From: [Grush, Matthew P.](#)
To: [Brianna Uy](#)
Subject: RE: NM0203 NEQ of 98th Street NW and Volcano Road, Albuquerque, NM: Development Review Services Submittal - TCL (K09D0488) TCL review 8/26/2022
Date: Friday, August 26, 2022 2:39:00 PM
Attachments: [TCL_revised 98th Undrawn 8/26/2022.pdf](#)

I have finished the initial TCL review date submitted 5/20/2022. Comments to be address before approval are as follows:

Please see the below link for the Traffic Circulation Layout submittal for a 950 SF Dutch Bros Coffee located on Tract D of the R5 Bluewater Addition on the northeast corner of 98th street NW and Volcano Road NW. The UPC is 100905706518130705 with address 99999 Volcano Road. I also attached the same documents if that is easier for you to download.

Job Number  
**22187**  
Sheet  
**C2.0**  
2019 DB  
Franchising USA, LLC

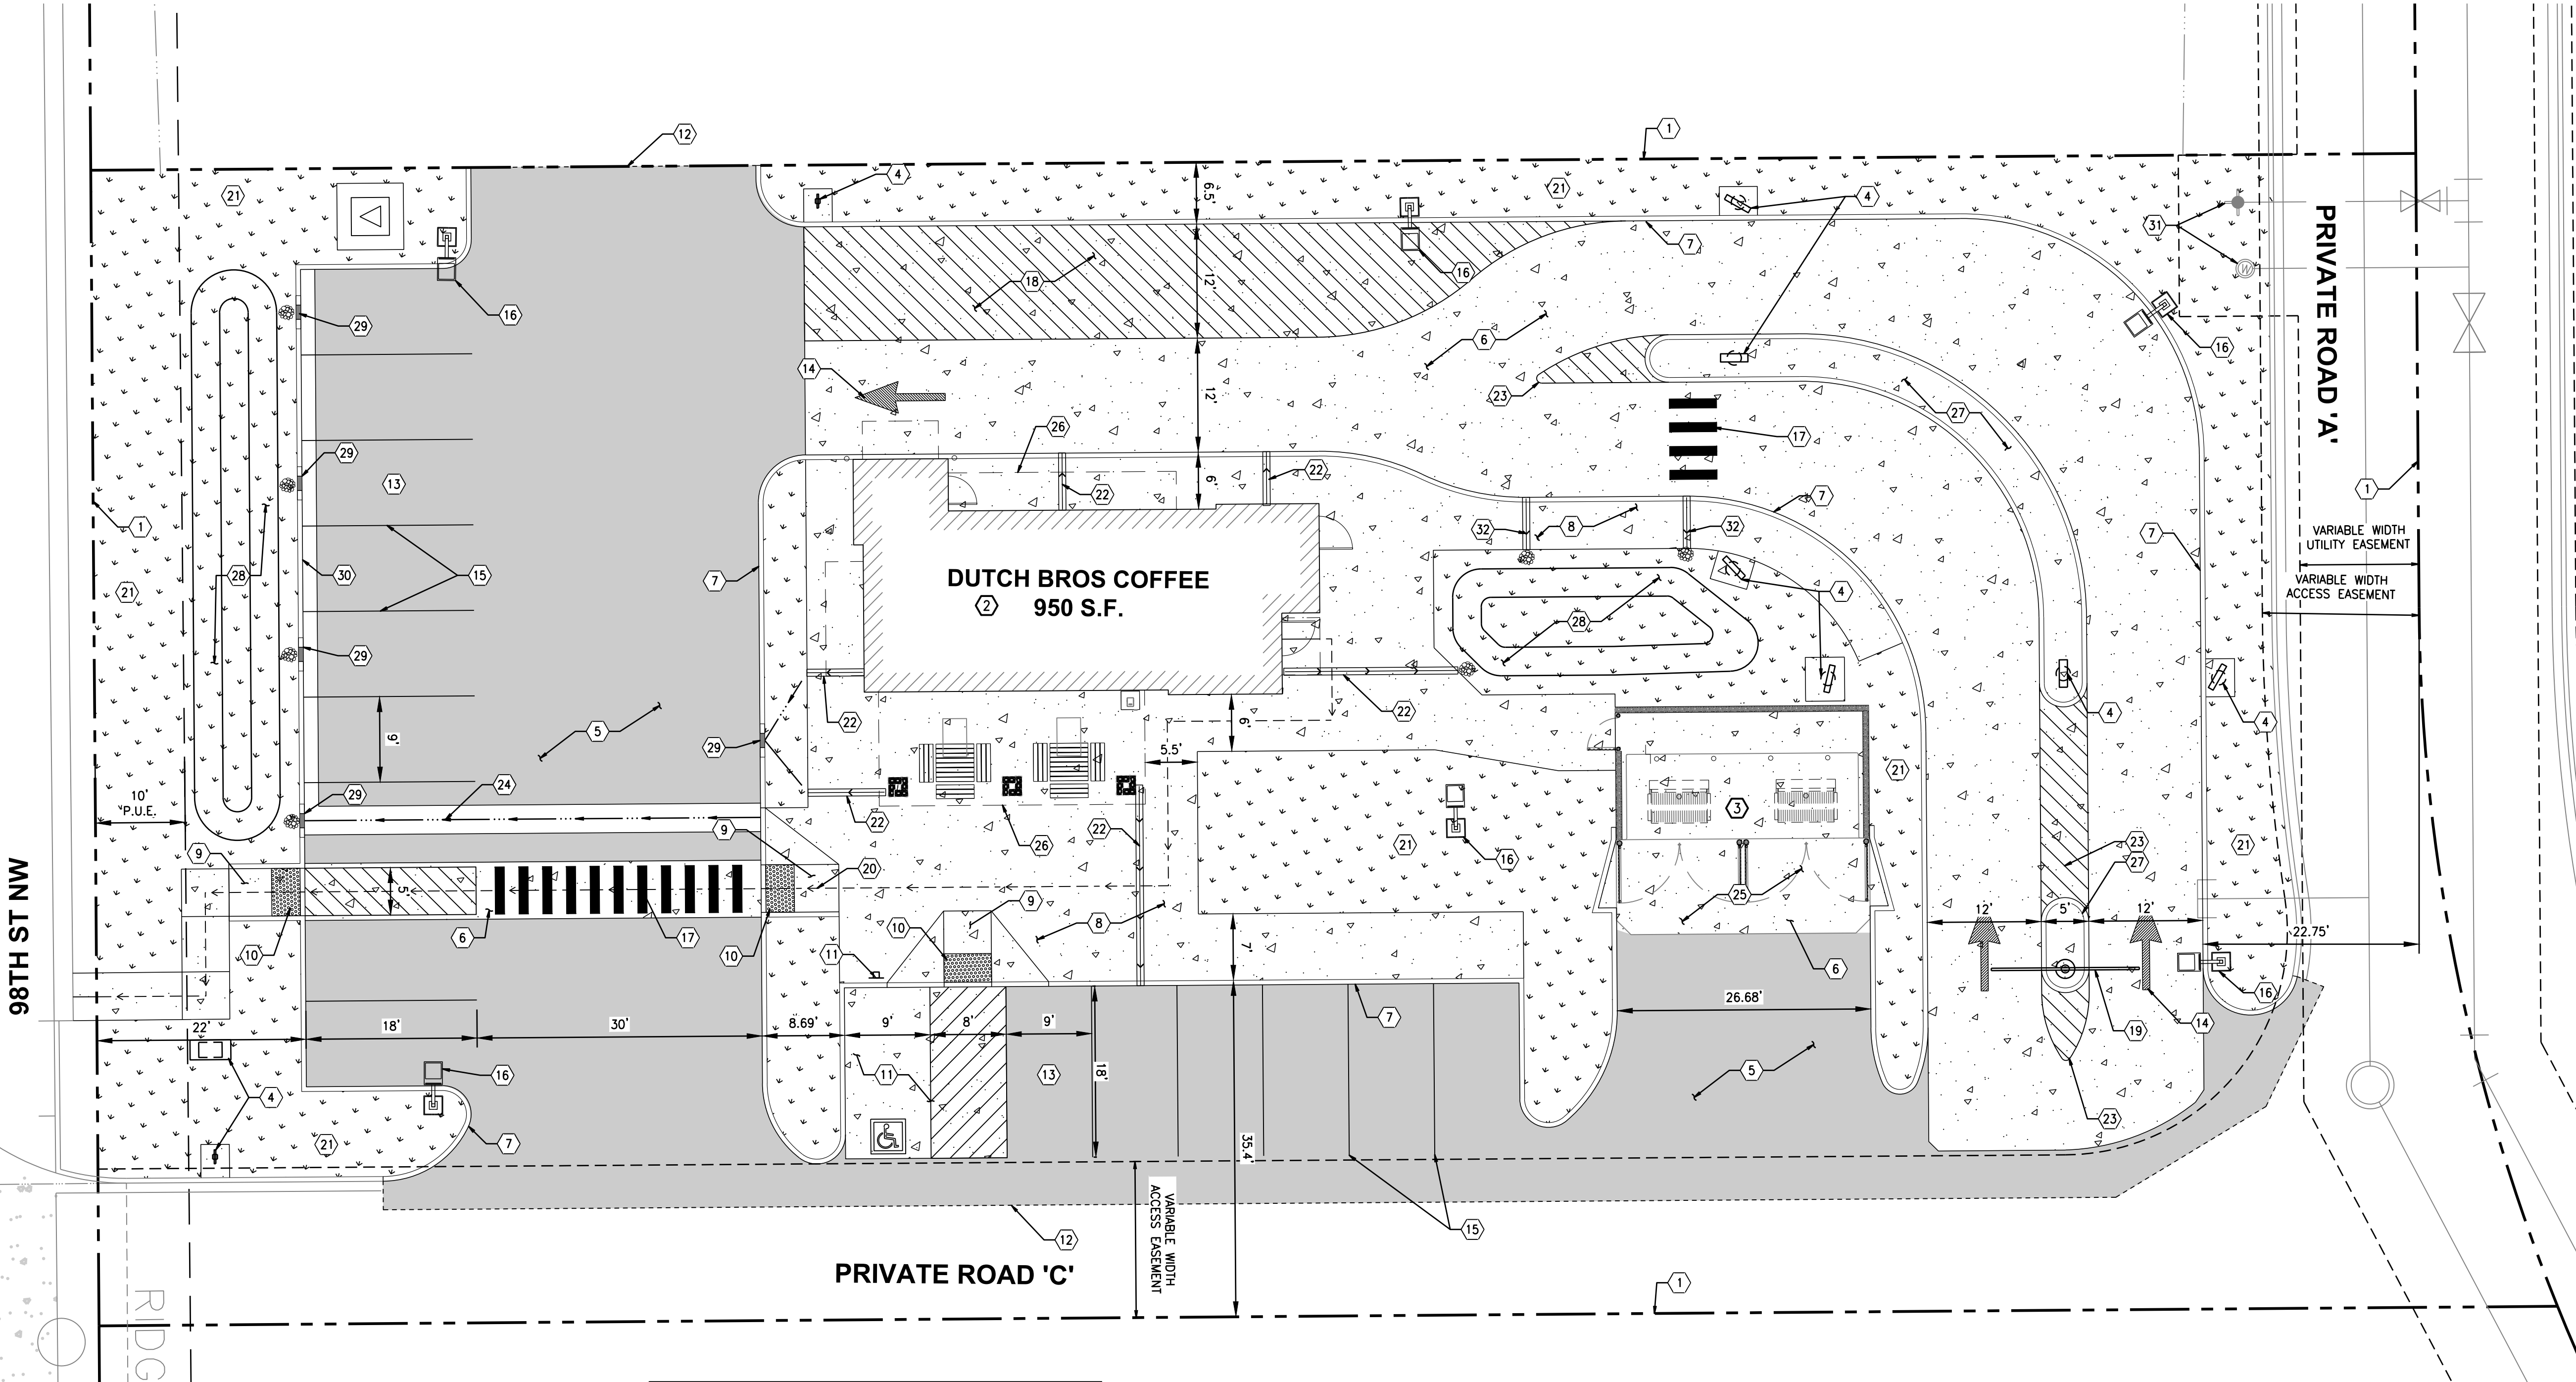
1. Include bicycle and motorcycle parking in the parking calculation
2. Reference all COA Standard Drawing numbers for Improvements in the City ROW.
3. Add a general note requiring City of Albuquerque Work Order plans for work within the City's ROW.

4. Identify street right-of-way widths and pavement widths and medians for adjacent streets.
5. Developer must provide sidewalk according to the COA DMP requirements along 98th St.

6. Signs. Provide sign face detail drawings for all proposed traffic signs. One-way, Do Not Enter, Motorcycle Parking, Handicapped parking with fine.
7. Place the one-way and do not enter signs with appropriate pavement markings in the site plan.

8. Add one Motorcycle Parking space with sign
9. Add three bicycle parking spaces. Provide bicycle rack details.
10. Build the 2 lane driveway at 98th with curb returns and valley gutter.

11. Show the delivery truck path and assure that there is sufficient clearance.
12. Provide Fire Marshall and Solid Waste approvals.
13. Increase the pedestrian sidewalk/pathway from the public sidewalk to the main entrance to 6 feet. Plans have a 5-foot wide path.

14. Show the sight triangles for the driveway on 98th and the driveway into the site.
